## CONSULTEE RESPONSE (Council's Arboriculturist)

Reference: P/43/25/PL

Proposal: Demolition of existing storage buildings and the erection of 6no. dwellings and associated works. This application affects the setting of listed buildings, is a Departure from the Development Plan and is in CIL Zone 5 and is CIL Liable as new dwellings.

Location: Land to the west of Inglenook Hotel, 255 Pagham Road, Nyetimber, PO21 3QB

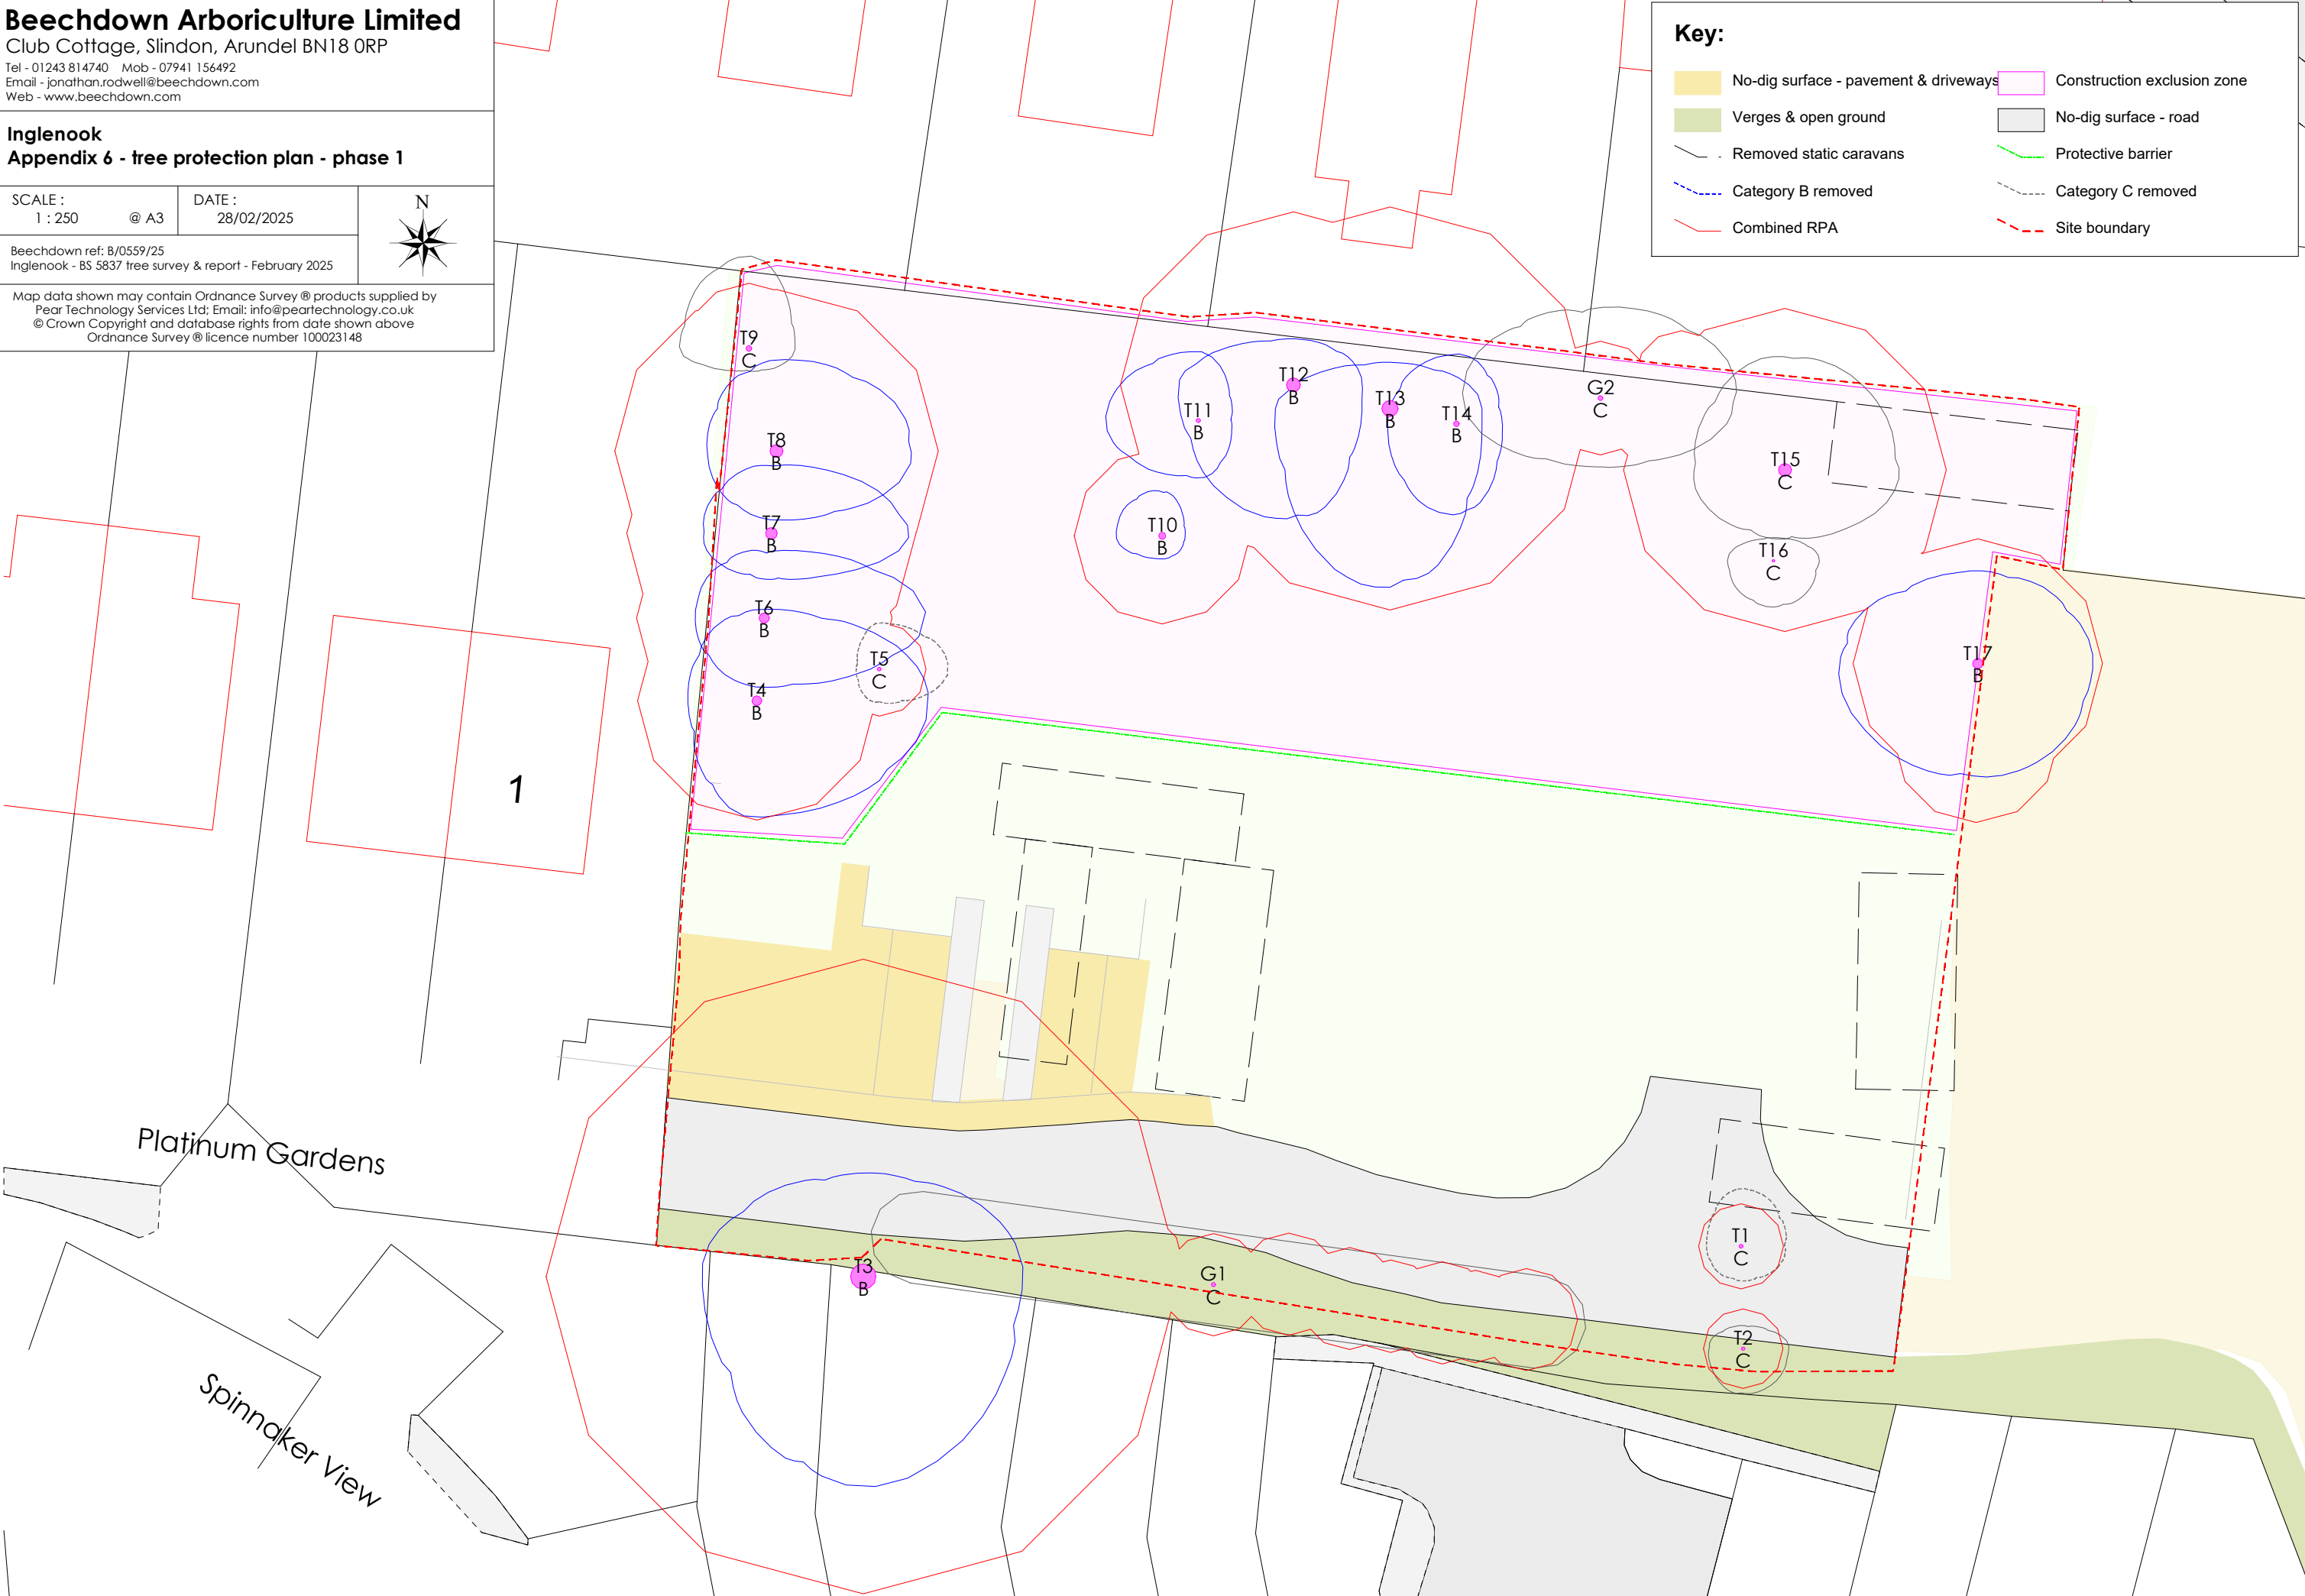
Before the site is occupied or any machinery is introduced to the site or demolition work or construction work or alterations to existing ground levels takes place, written confirmation is required from the Arboricultural Expert representing the site owner(s), confirming that all protective fencing has been inspected and found to be 'Fit for Purpose' as required under British Standard 5837:2012 and been erected and positioned exactly as shown on the **Tree Protection Plan – Phase 1, ref. B/0559/25, Beechdown Arboriculture Ltd.**

Inglenook
Appendix 7 - tree protection plan - phase 2

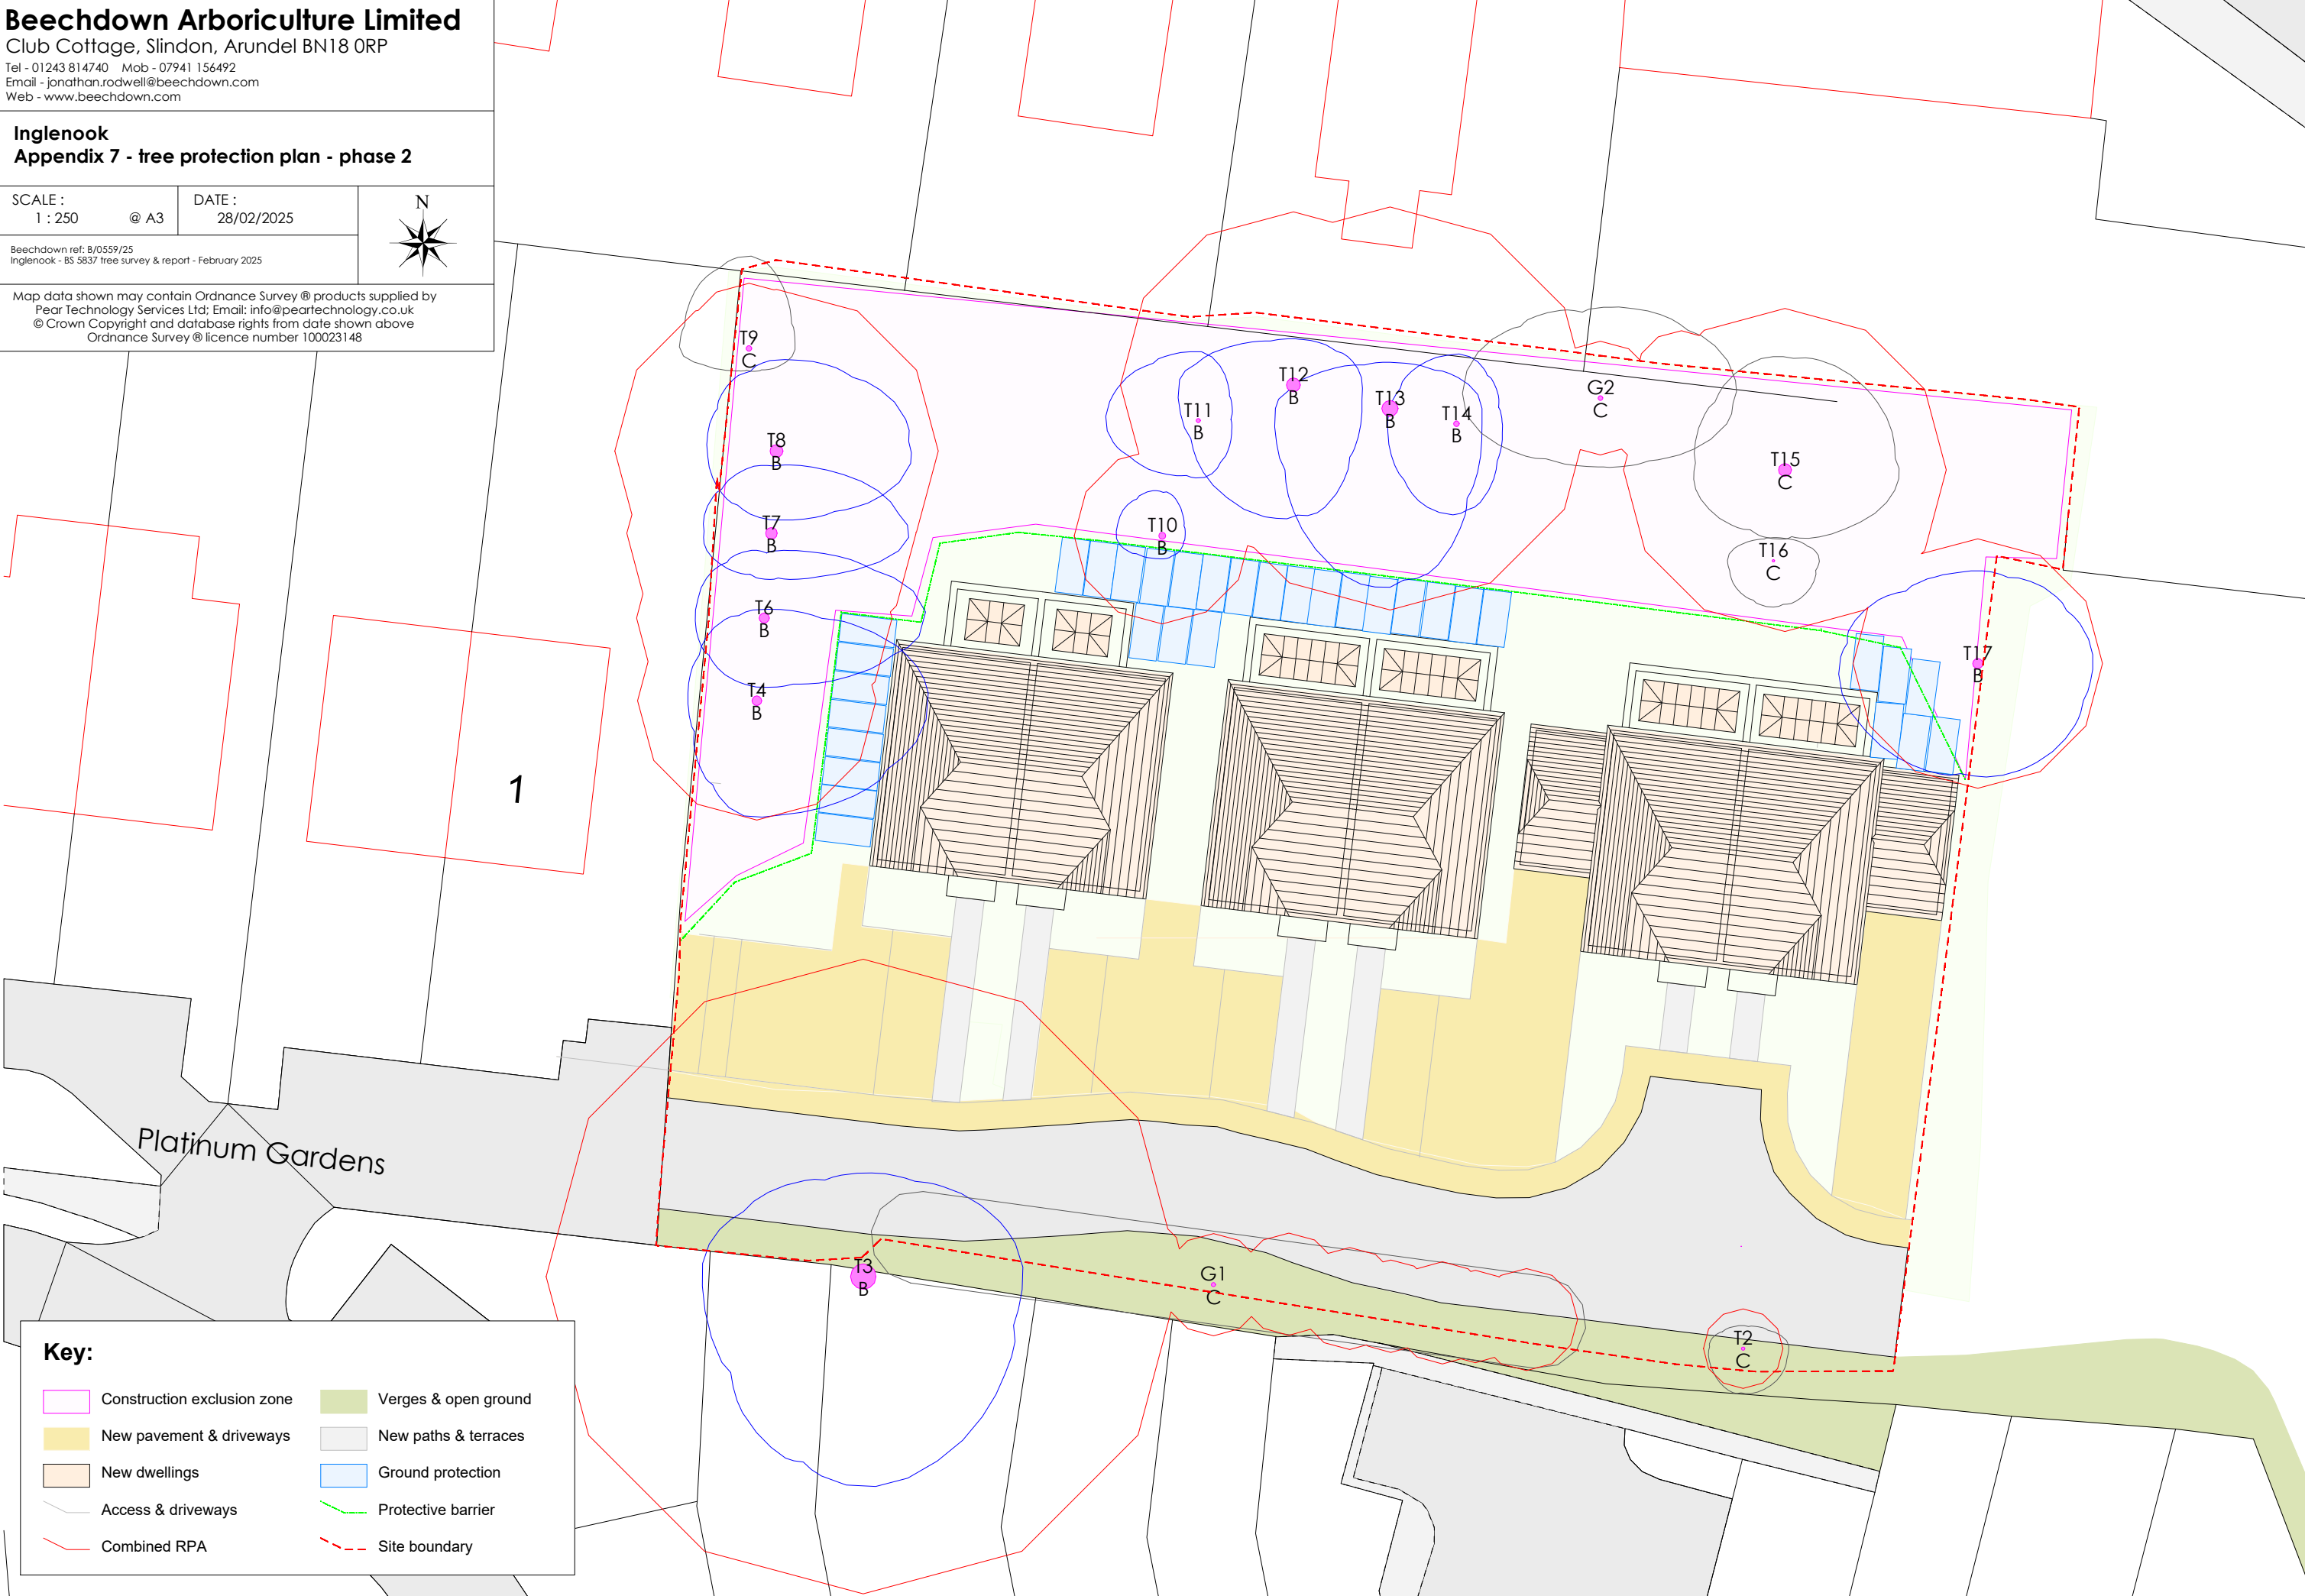
Trees T4 & T6-T8 incl. growing near the west boundary are subject of a preservation order – TPO/P/2/20. This linear group of early mature native oak and lime have limited amenity potential, following facilitation pruning on their west aspect to accommodate an earlier development (Platinum Gardens) and their partial concealment by dwellings. This effect to be replicated on their east aspect should this latest proposal gain approval.

The above pruning should leave a minimum radial spread on the east aspect of 3.5metres, resulting in a balanced crown profile and allowing sufficient clearance from the dwelling and reasonable use of garden space.
